Y/7/22/PL

Land adjacent to Bonhams & Flints Hoe Lane Flansham PO22 8NP

Erection of 4 No dwelling with access from Hoe Lane and associated landscaping, including native orchards and wildflower meadows.

1 ELEVATION into COURTYARD (EAST)
Scale: 1:100

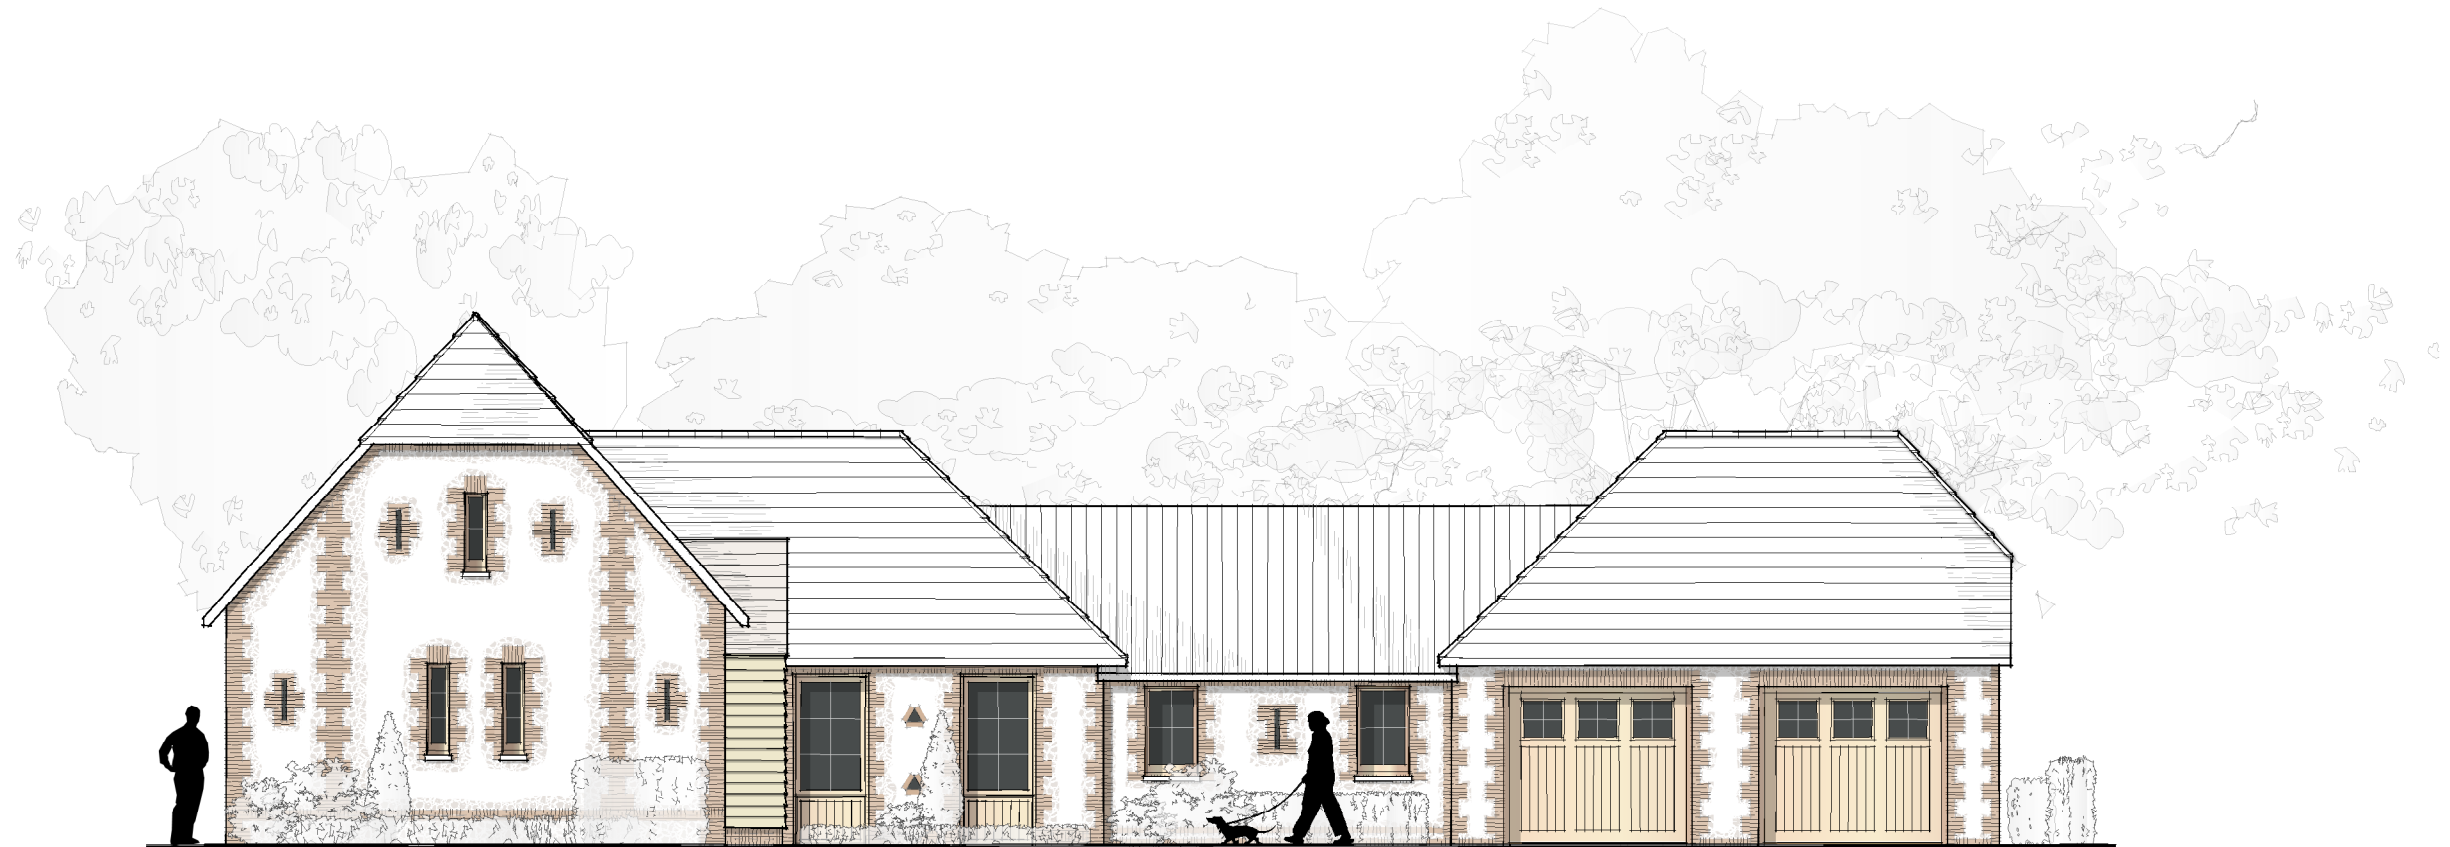
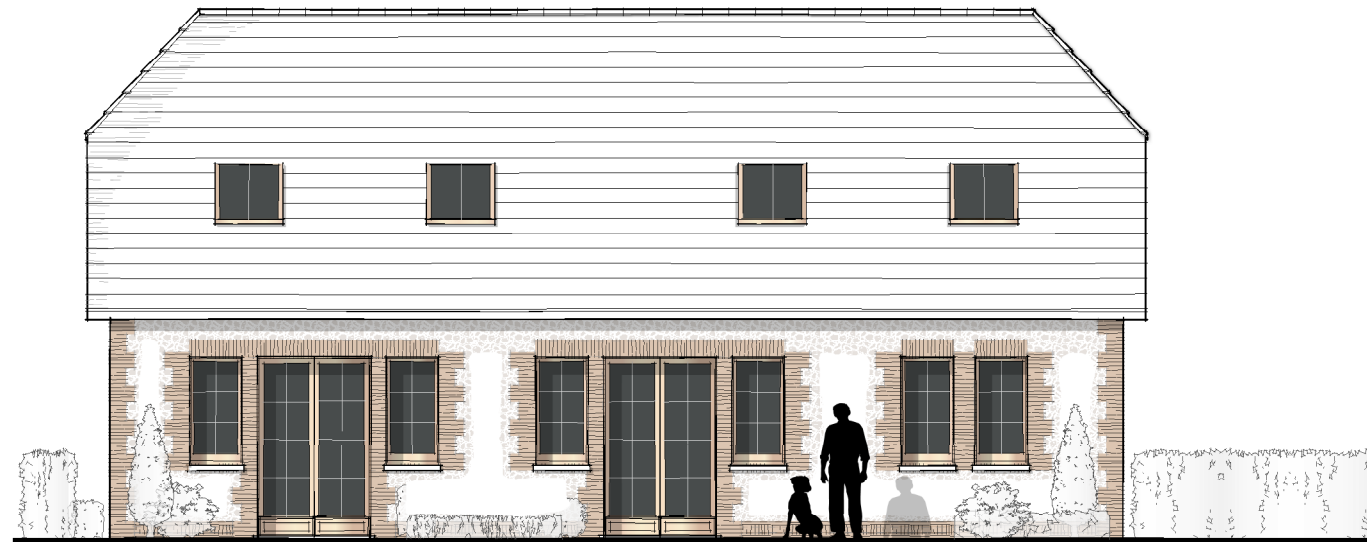
The design of the new dwellings attempts to make them look as though there were converted from supposed former barn structures, with a number of details that the applicants consider are reflective of their supposed former use. I note that the design and access statement identifies that the roofs will be clay tiled and windows and doors will be of traditional timber joinery. All elevations will be finished in flintwork with brickwork detailing framing the windows and doors. Such materials will attempt to help soften the buildings and help in their suggested former barn complex context. Having considered this approach, I am of the opinion that there is some logic to this. However, the success of the design will be down to details and other materials proposed. For instance, it is suggested that the use of the pre-made concrete and flint blocks will detract from the final appearance and not be suitable/supported. Further, that the windows and doors should be appropriately designed (no applied glazing bars etc.) and positioned within their openings so as to create the appropriate shadow lines. Likewise, other materials should be appropriate for the type of buildings proposed and the roof lights should be of a conservation standard. Although, it is not fully clear why so many roof lights are needed and it is considered that these detract from the

somewhat traditional elevations proposed. These details (and others) should be conditioned should you be minded to recommend approval.
